Our Ref: SJB/nm/21046_01

22 October 2021

TOWN AND COUNTRY PLANNING ACT 1990
APPEAL BY MS PARAMJIT SIDHU
279 SWAKELEYS ROAD, ICKENHAM UB10 8DR
APP/R5510/W/21/3282070

Drawing
Proposed Ground Floor Plan
-
-

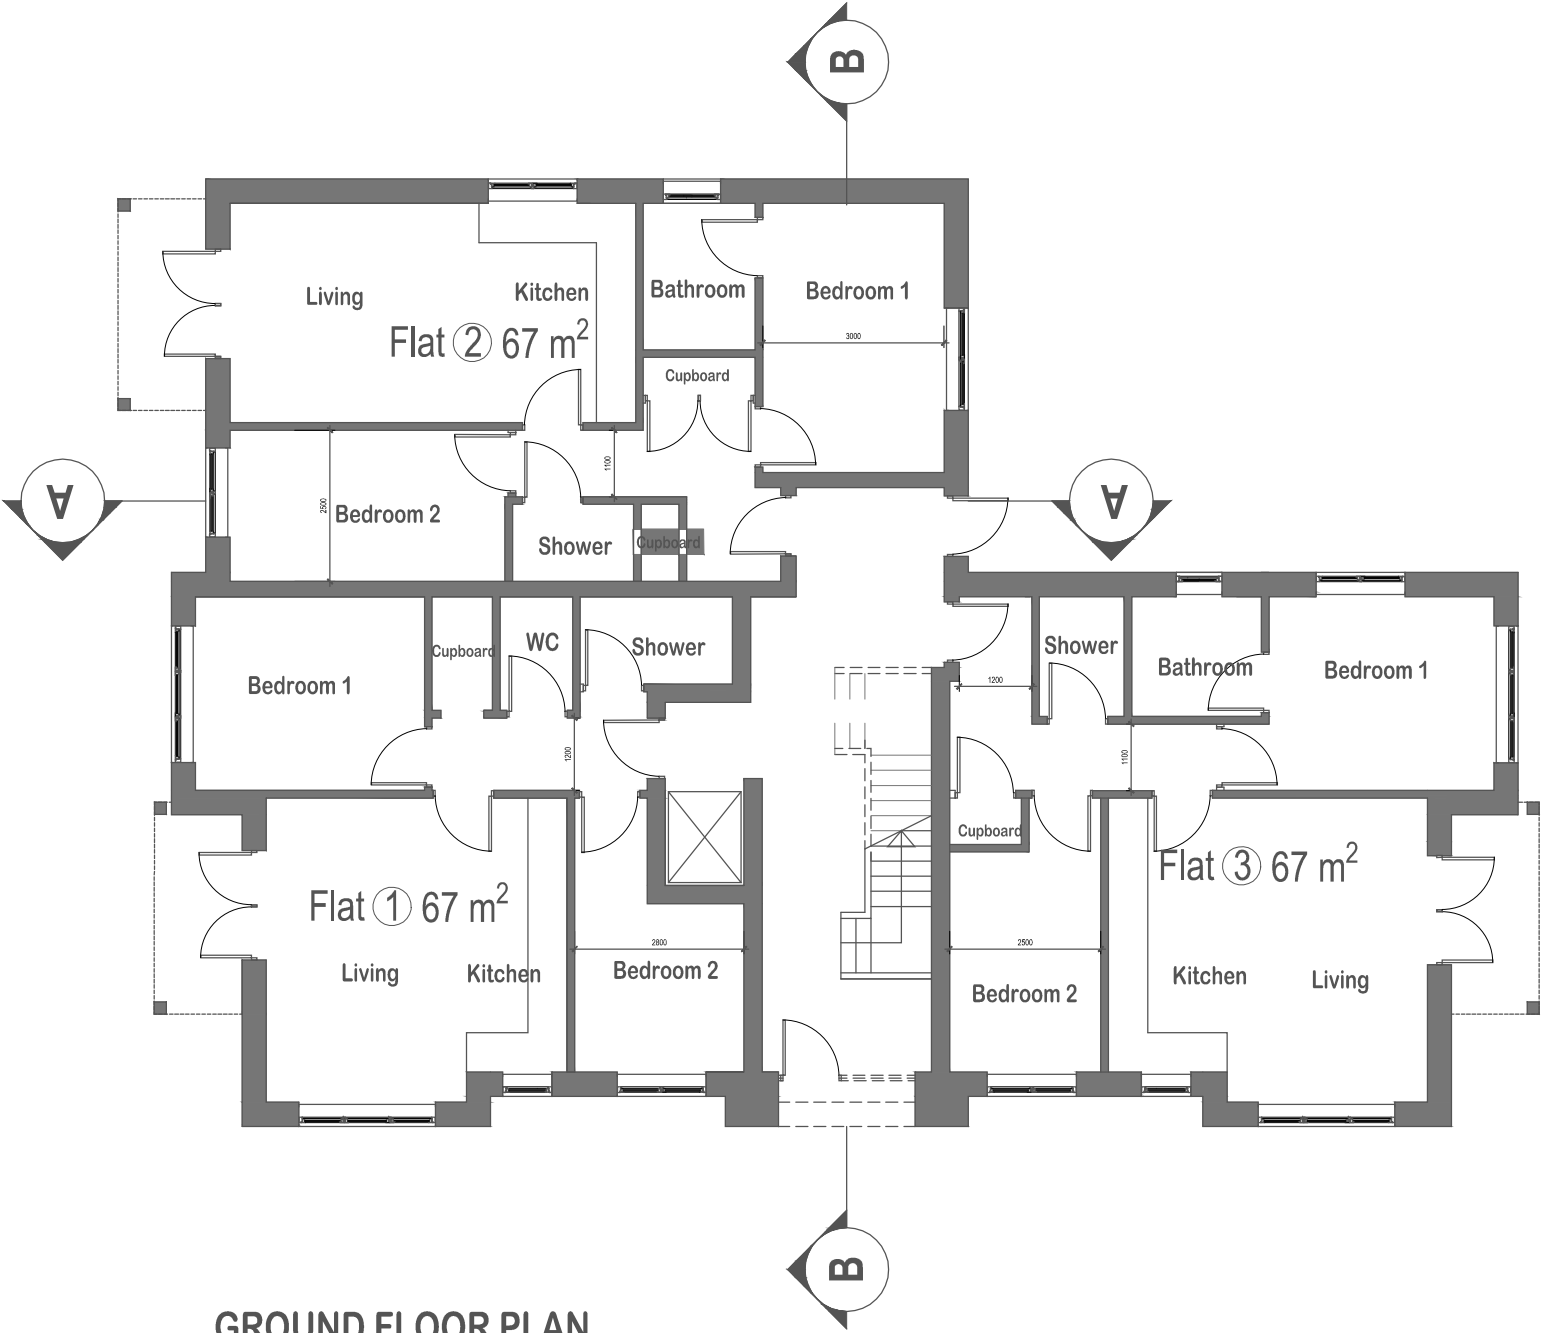
On the matter of the plans, and to recap, the 'flat' plans are revised to clarify, explain and show the arrangements for amenity space. The only other plan change is the inclusion of the lift on the floor plan.

Proposed Roof Plan
-
-

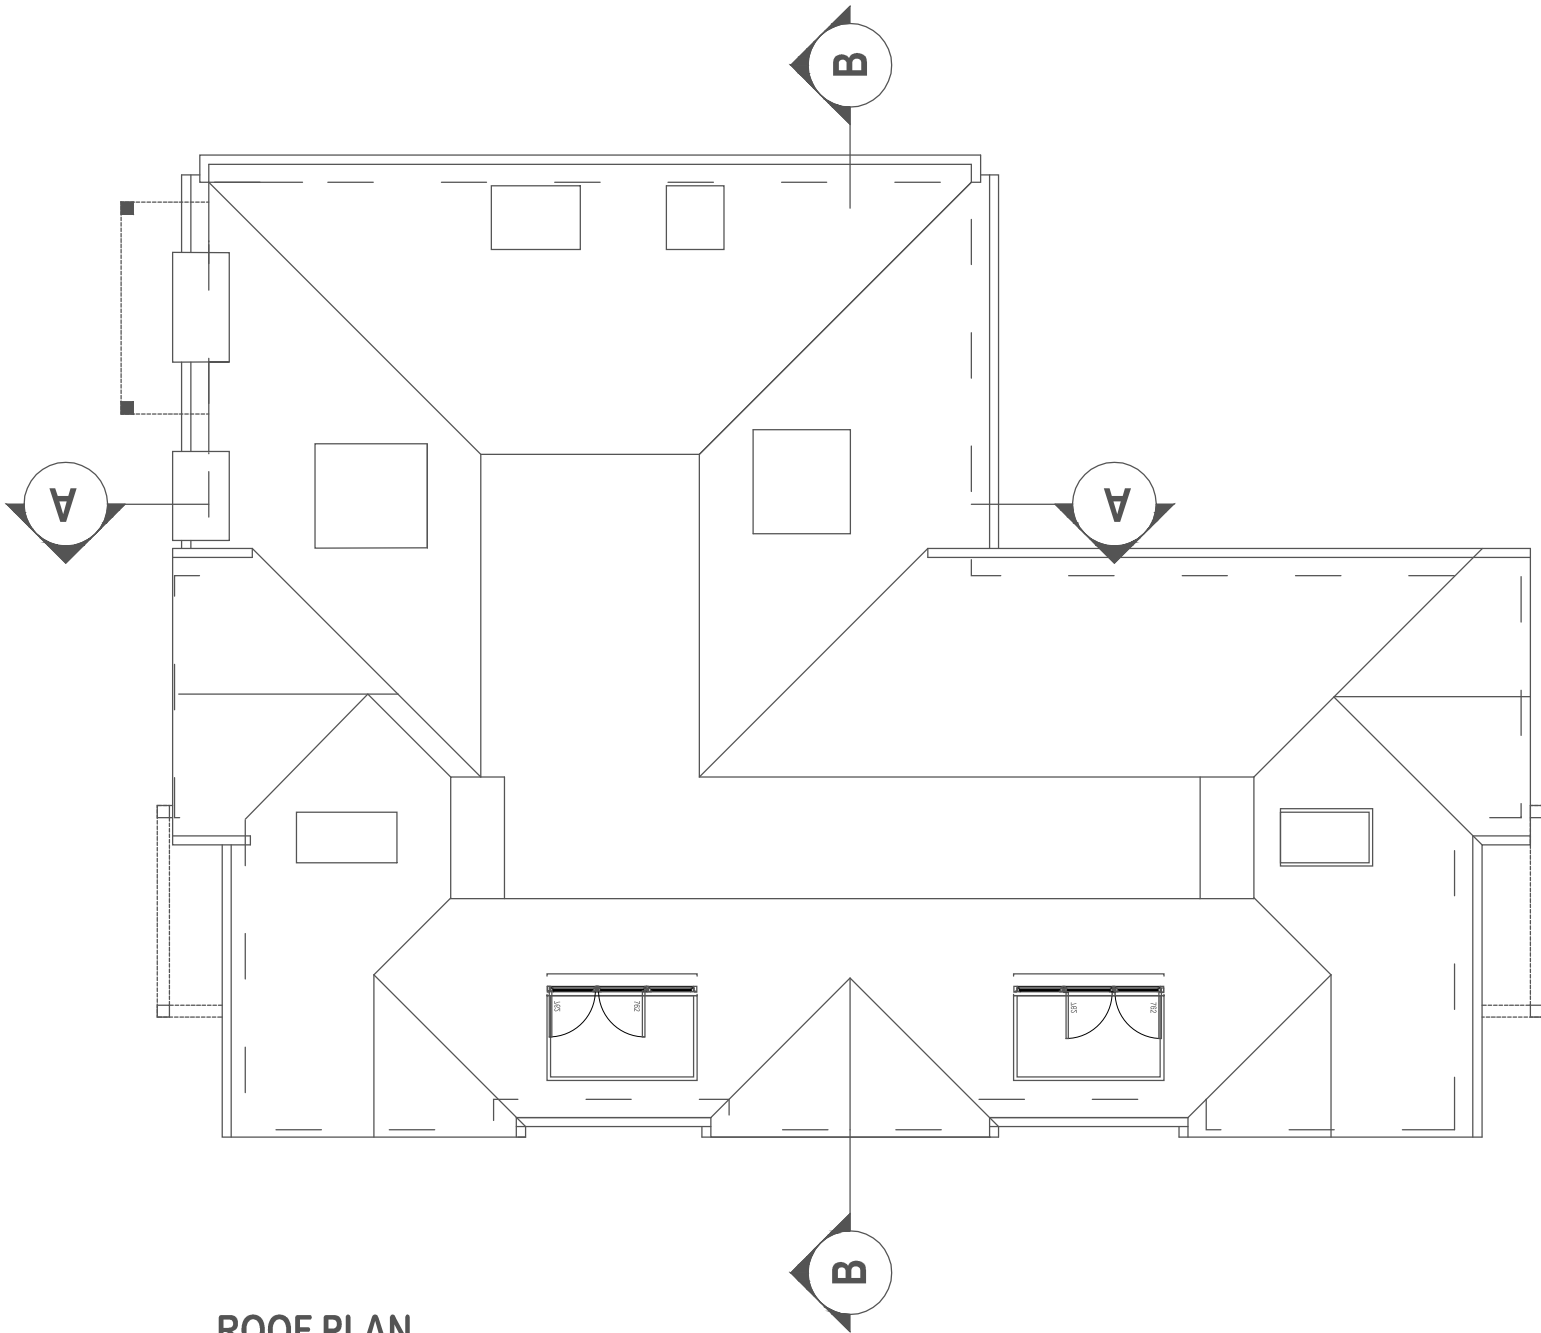
There was no *"implying"*, as is suggested, that the 10.5 main ridge height (our Statement of Case [SOC] 5.12) was out of character. The point being made is that if the Inspector, as decision maker, accepts the Council's position, the revised ridge (incorporating a small flat-top) addresses that concern. Should he or she not concur, the original drawings are before him/her.
